DEVELOPMENT REVIEW BOARD – SPEED MEMO

DRB CASE NO/PROJECT NO: 1006500

Sketch Plat

RE: Anderson Heights/Units 6 & 7/sketch

ANDERSON HEIGHTS UNITS 4 & 6
SKETCH PLAT FOR SUBDIVISION

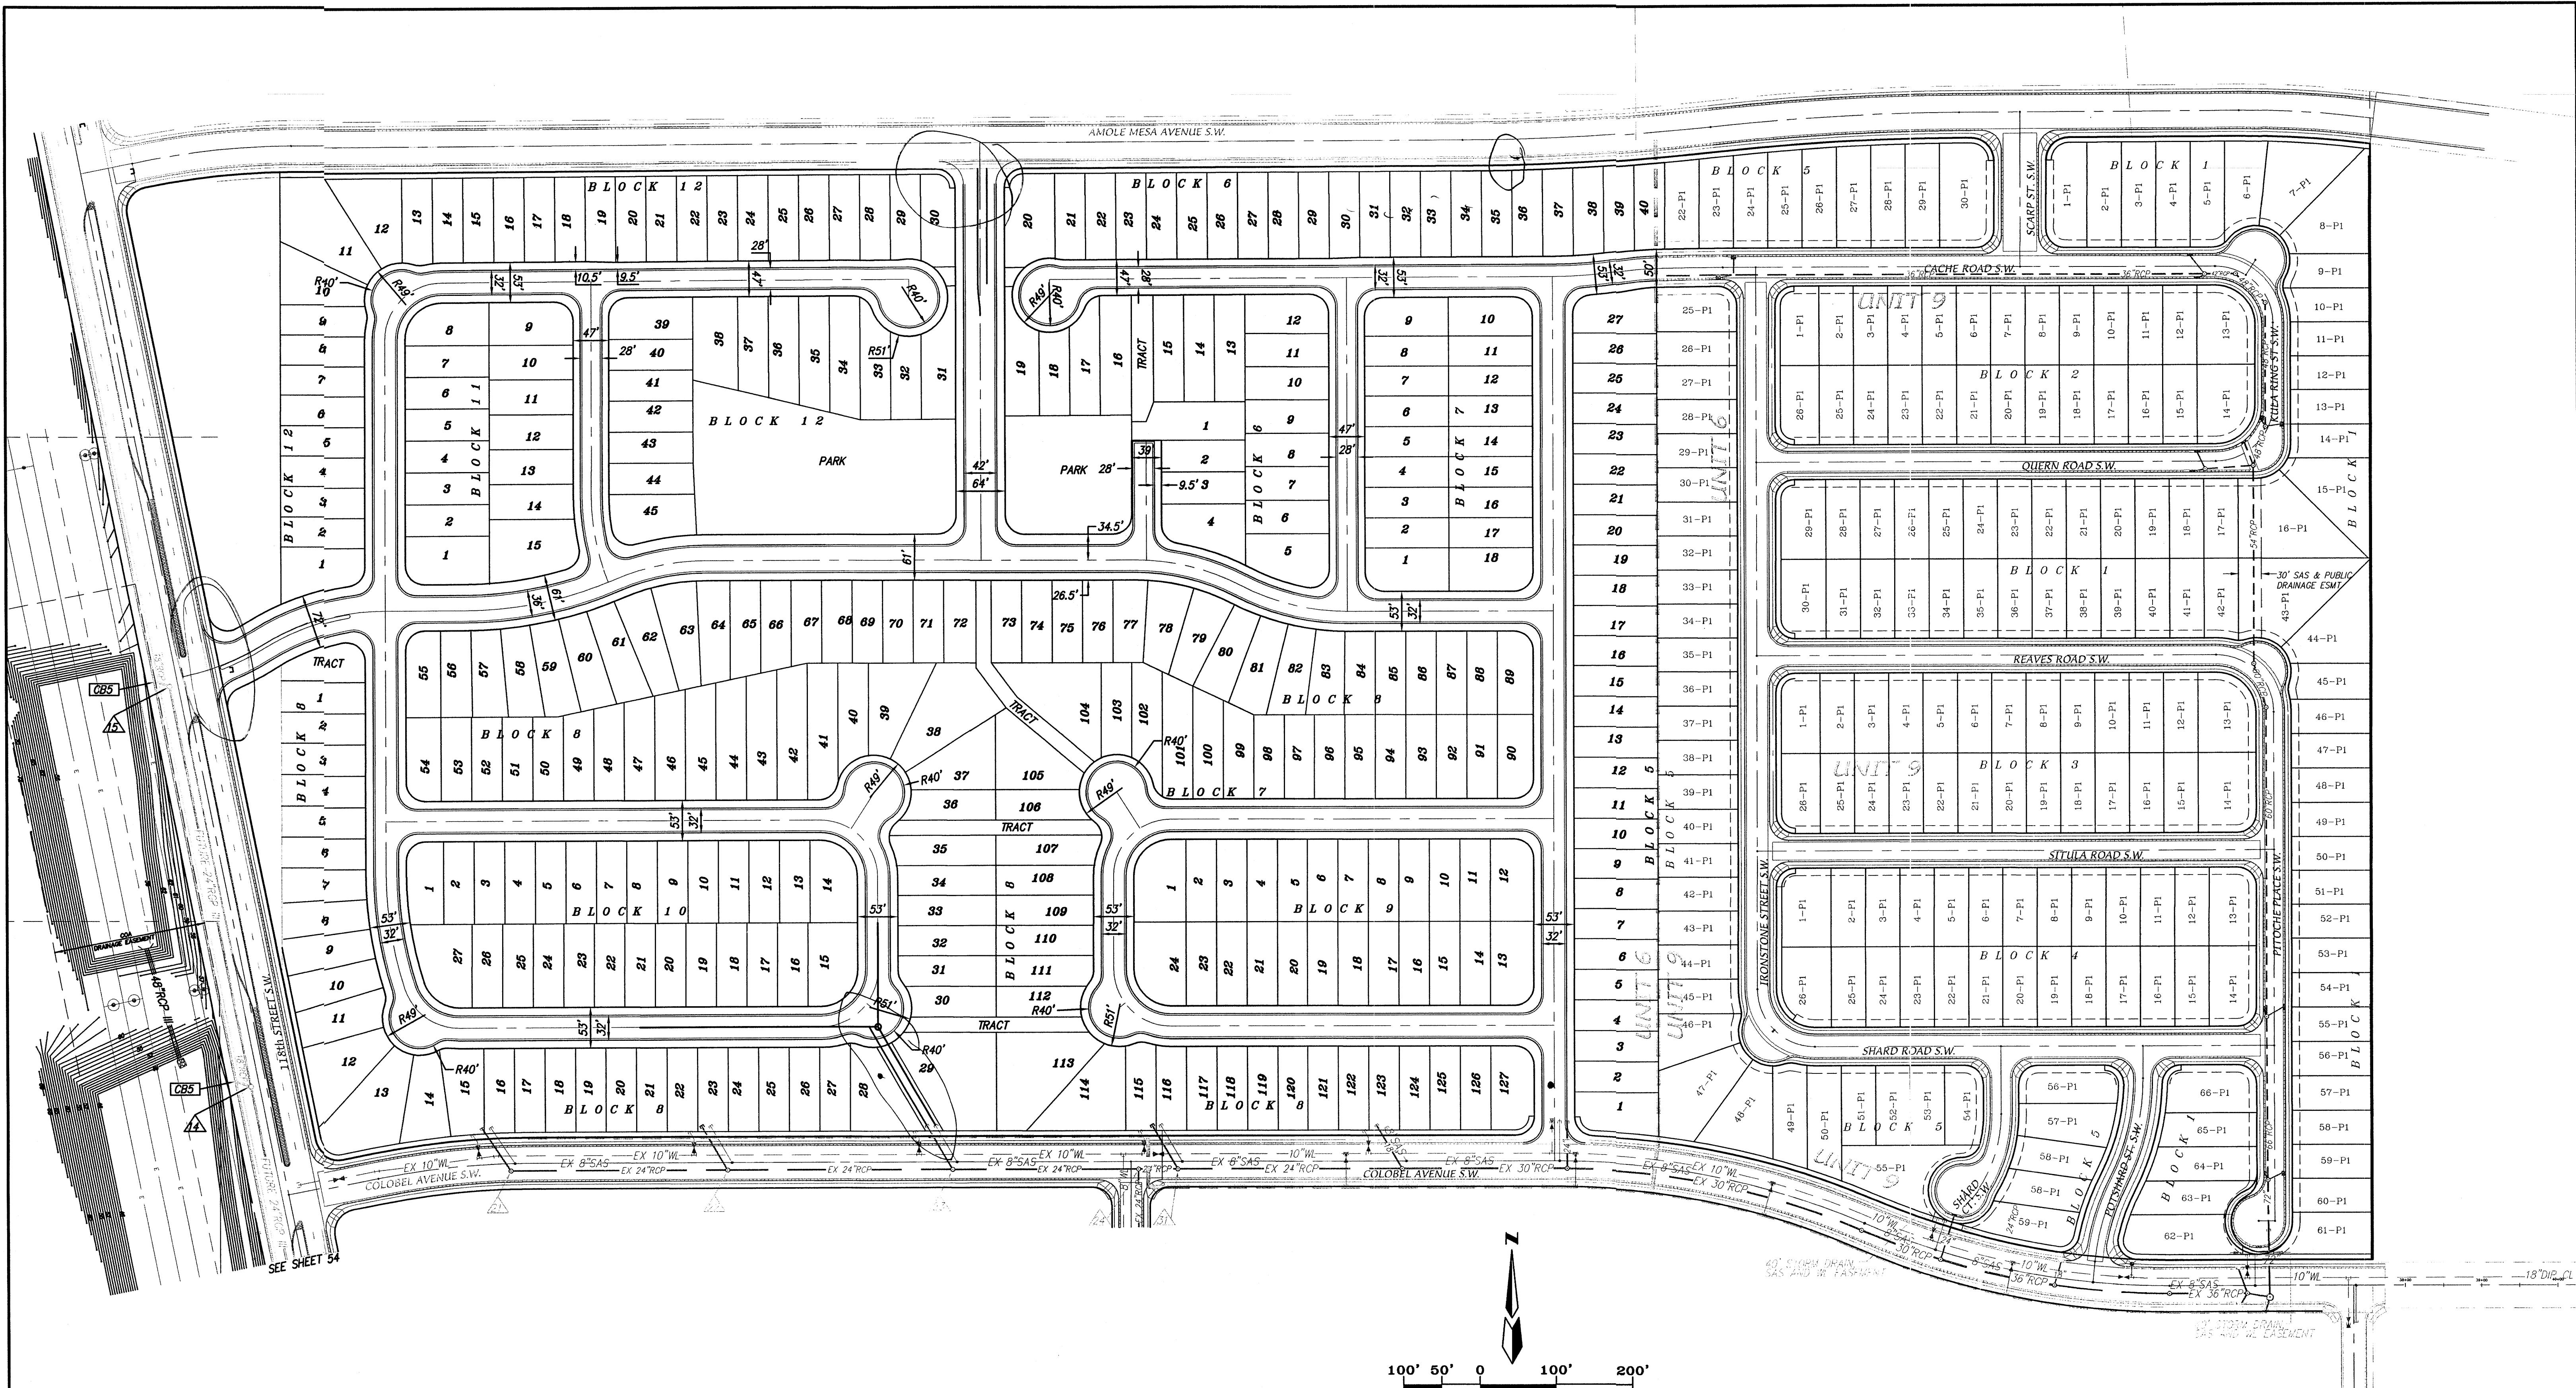
- Amended site plan for subd.
- pedestrian access.
